29 March 2016

Glenfield Waste Services Resource Recovery Facility (SSD 6249)

Council's technical officers have reviewed the exhibited documents for the Resource Recovery Facility and provide the following comments:

| Map Title: | Figure 3-2: Site Layout Plan | | | | | | Date: | 30 July 2015 | ENVIRONMENTAL PROPERTY SERVICES | |

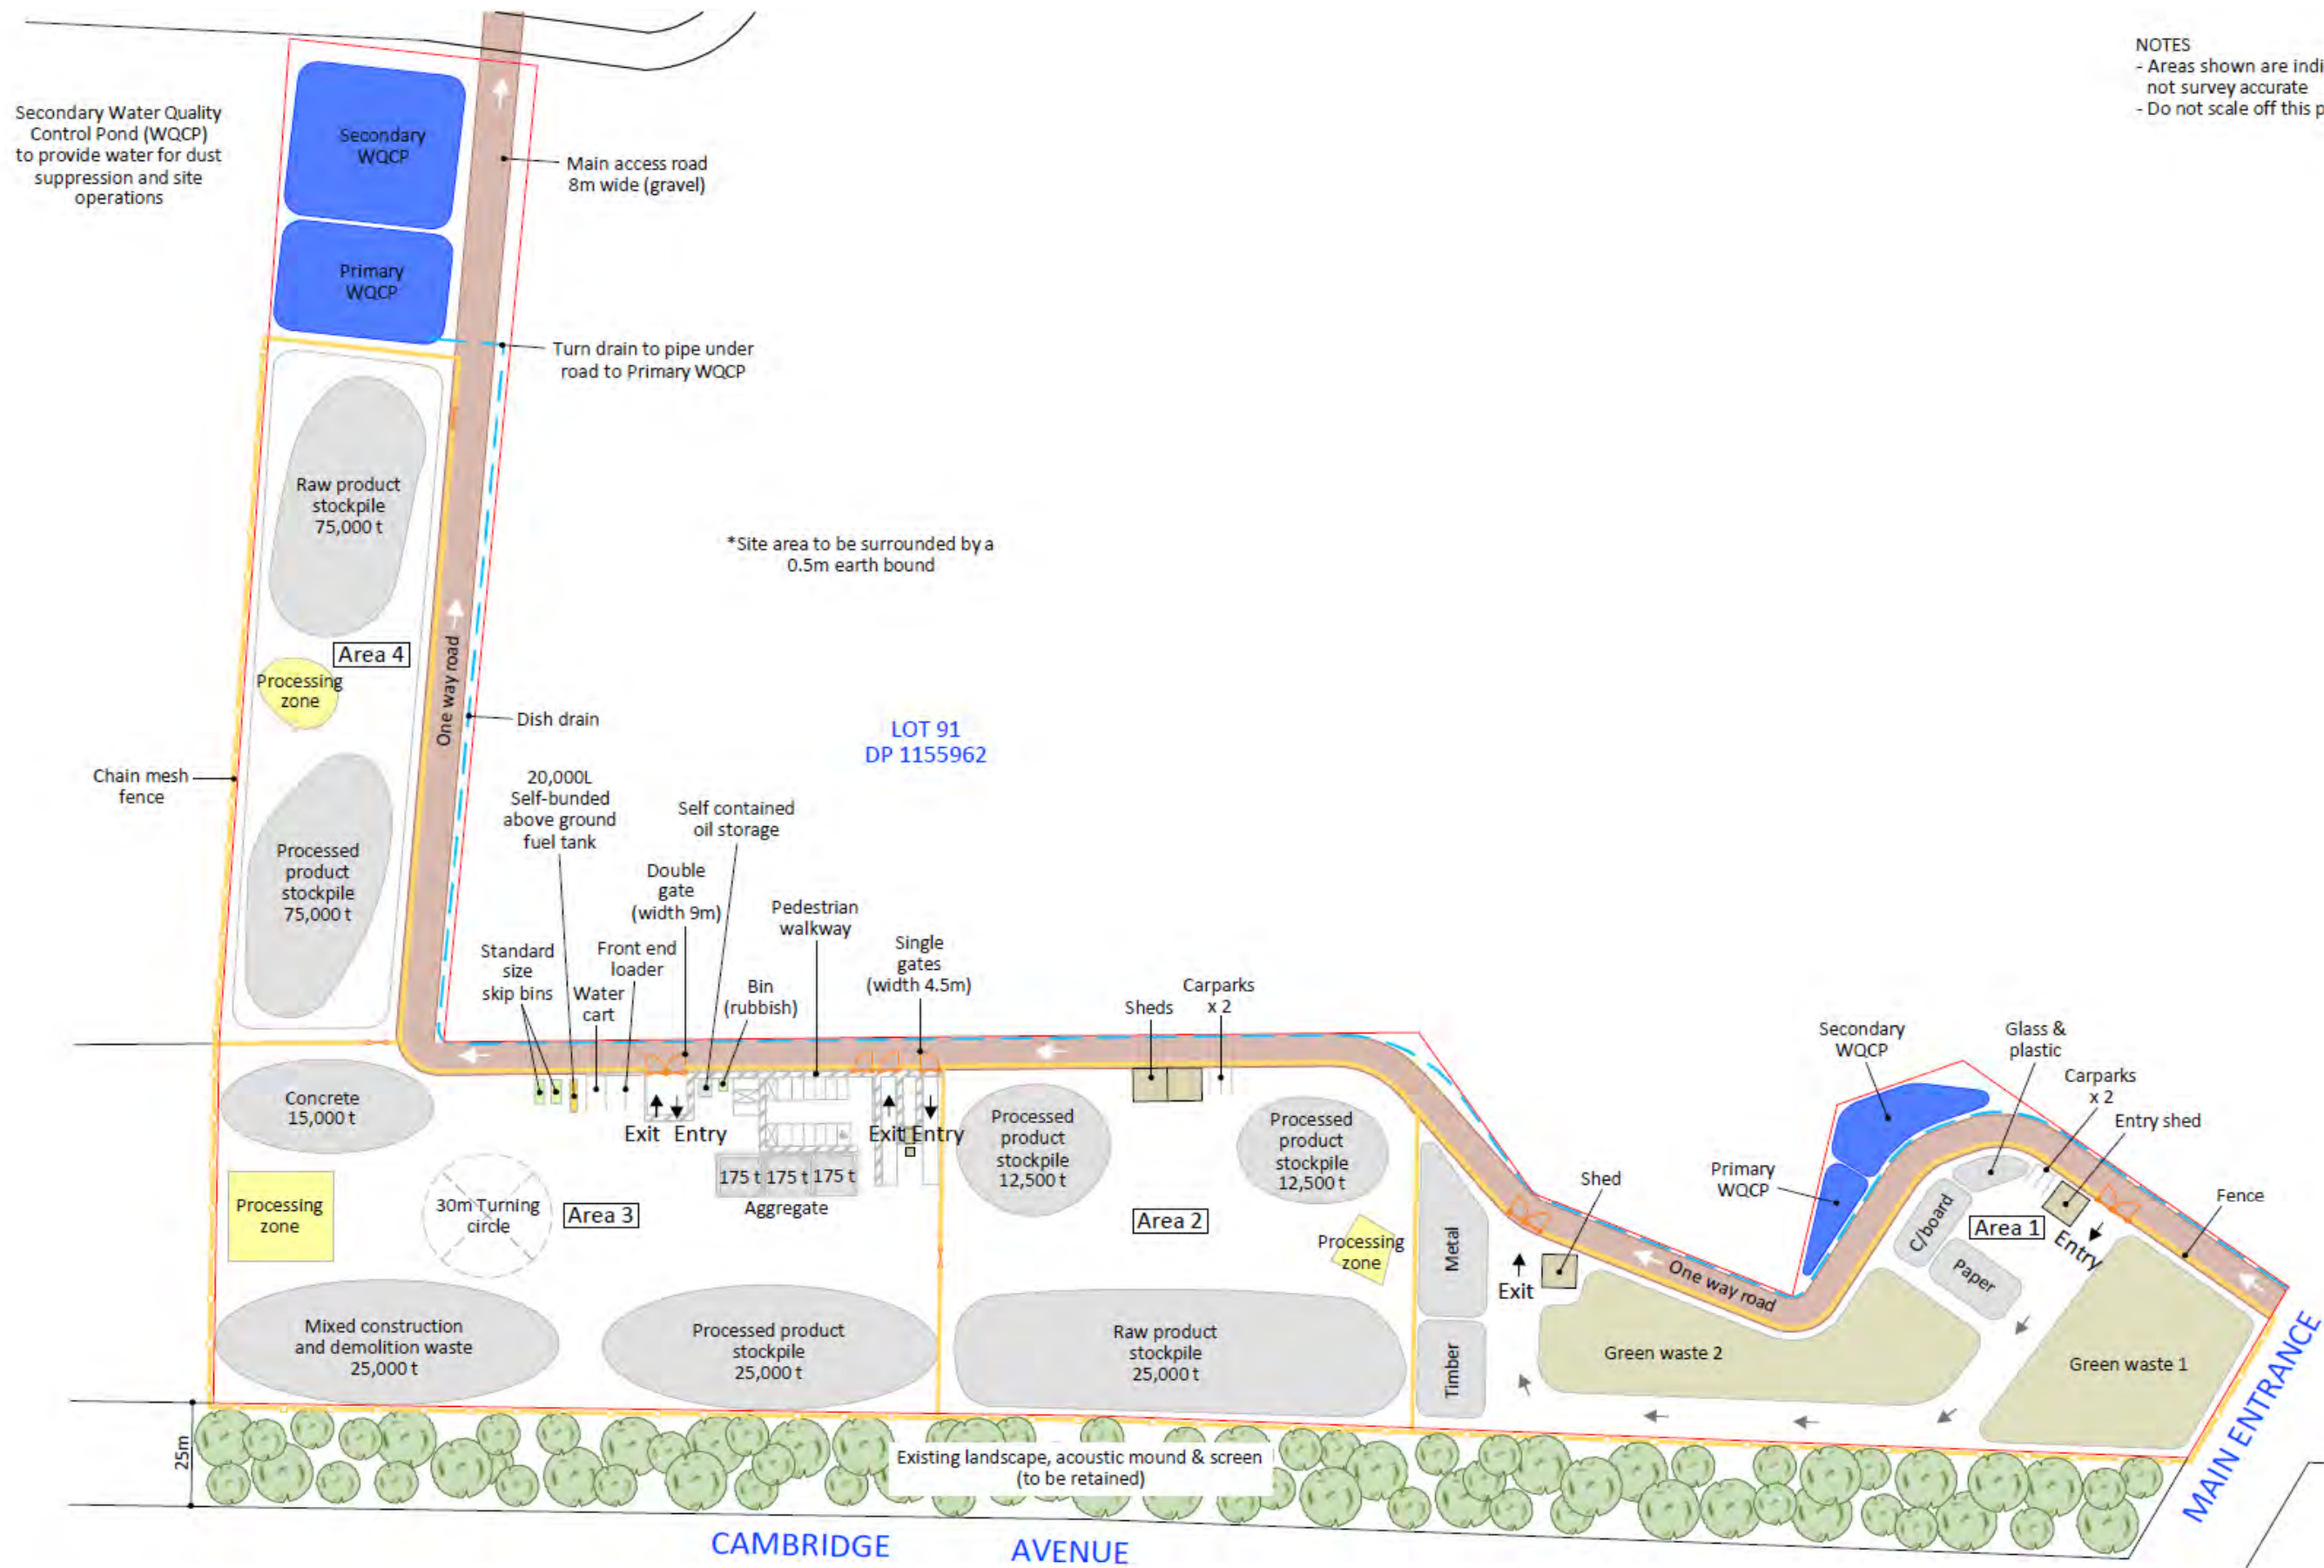
- h. The internal road is quite narrow and the proposed vehicles accessing the site are very large. It will be necessary to demonstrate that the vehicles can safely negotiate the internal road network. Turning path diagrams for applicable vehicle sizes and speed environments are required.

6. The plans provided are very basic but indicate that there is a single swale on the north and western side of the haul road, directing flows to the water quality control ponds. The site generally grades in this direction. There are concerns that to get to this swale, surface flows will traverse the whole site, maximising the mobilisation of sediment and other pollutants. It also means that in times of continuing rain, the haul road will be subjected to surface flows, which may increase the amount of material picked up on vehicle wheels and transported off site. Details of the stormwater system are to be provided and must address the above concerns.

7. The document proposes that the roads within the site will be unsealed. This then necessitates the haul road to be wetted down multiple times a day to suppress dust. This is not seen as a viable option and the internal haul road is to be a fully engineered pavement and sealed to minimise the transport of material on vehicle wheels to the public road system. As the storage areas will not be sealed, it will also be necessary to provide a system to remove material from vehicle wheels before leaving the storage areas and entering the haul road.

| Map Title: | Figure 3-3: Operational Flows | | | | | | Date: | 30 July 2015 | ENVIRONMENTAL PROPERTY SERVICES | |

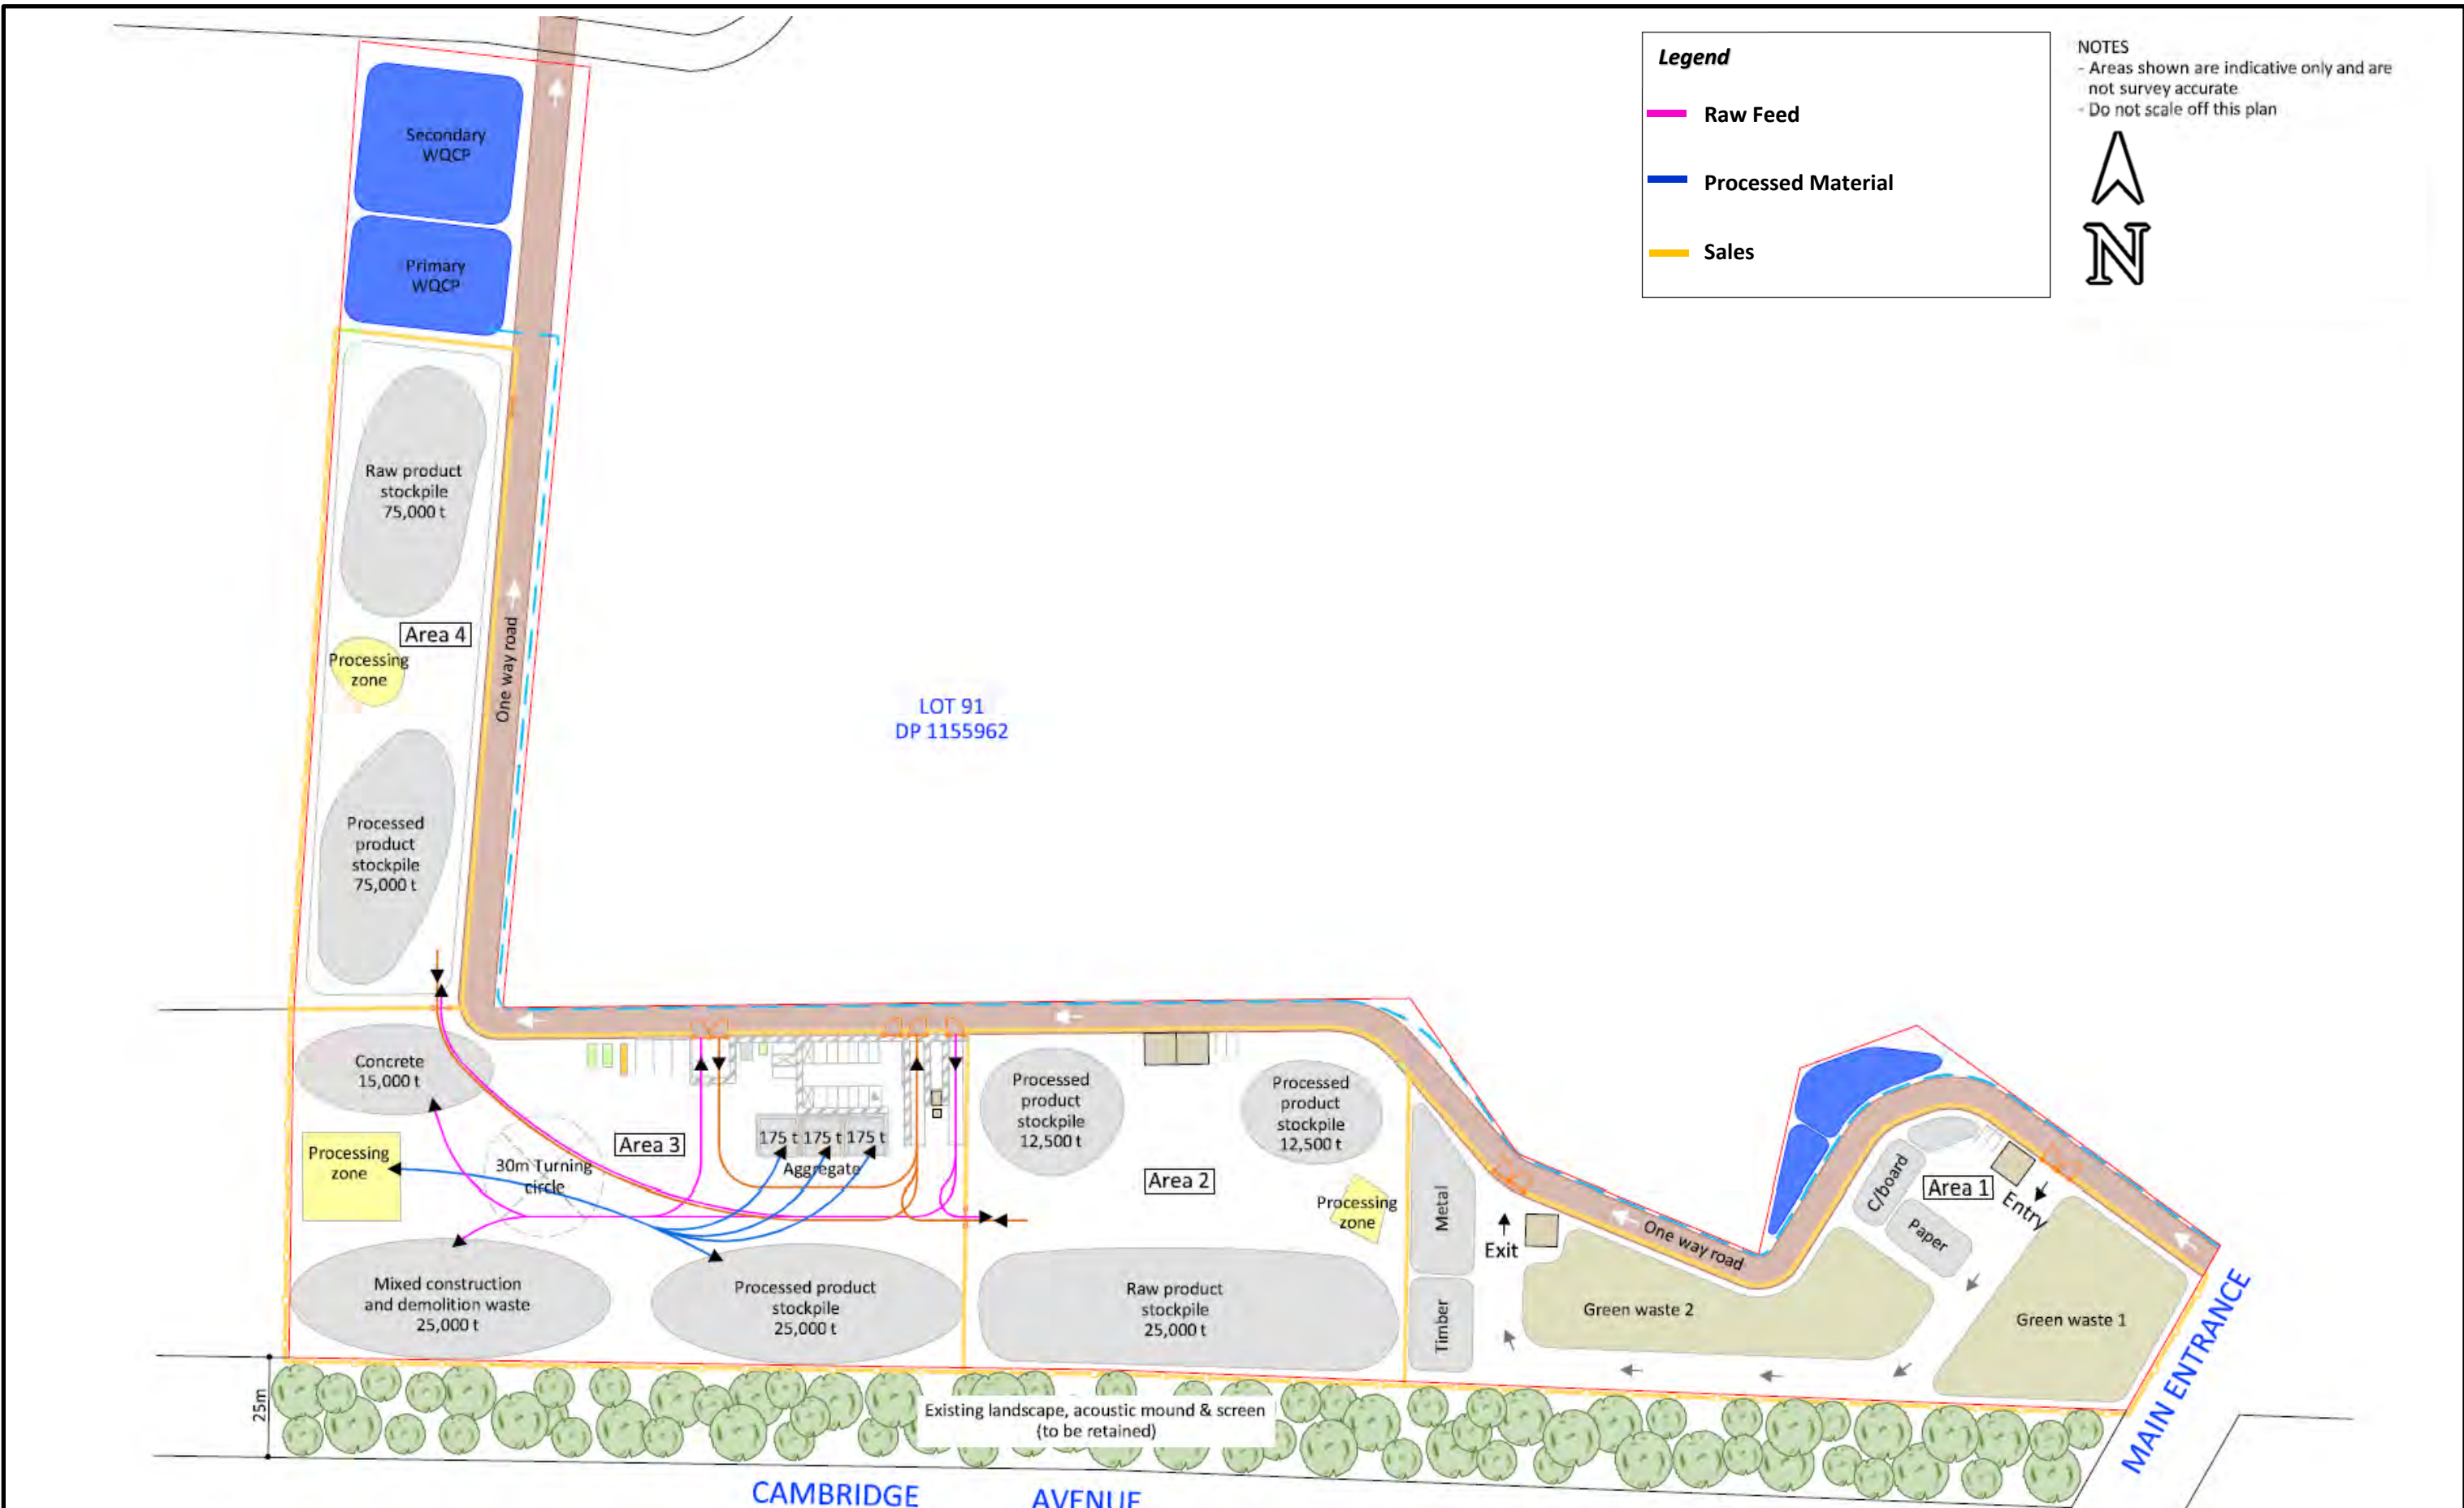
- c. Details will need to be submitted regarding how egress from the site to Cambridge Avenue for vehicles other than B-Doubles will be restricted.
- d. Similarly, as the internal road is designated as a one way road, how will a B-Double navigate back to Cambridge Avenue?

- g. The report indicates that vehicles accessing the landfill will continue to enter and exit the site at Cambridge Ave while traffic accessing the Recycling Facility will enter from Cambridge Avenue and exit via the Railway Parade Roundabout (with the exception of B-Doubles, which will exit via Cambridge Avenue). It is unclear how vehicles will be managed on site to ensure that this happens. Given the need to reduce vehicle

conflict on Cambridge Avenue, this is an essential part of this proposal. The applicant will need to submit a Traffic Management Plan to demonstrate how they will police these vehicle movements to ensure no additional burden on Cambridge Avenue due to turning vehicles.
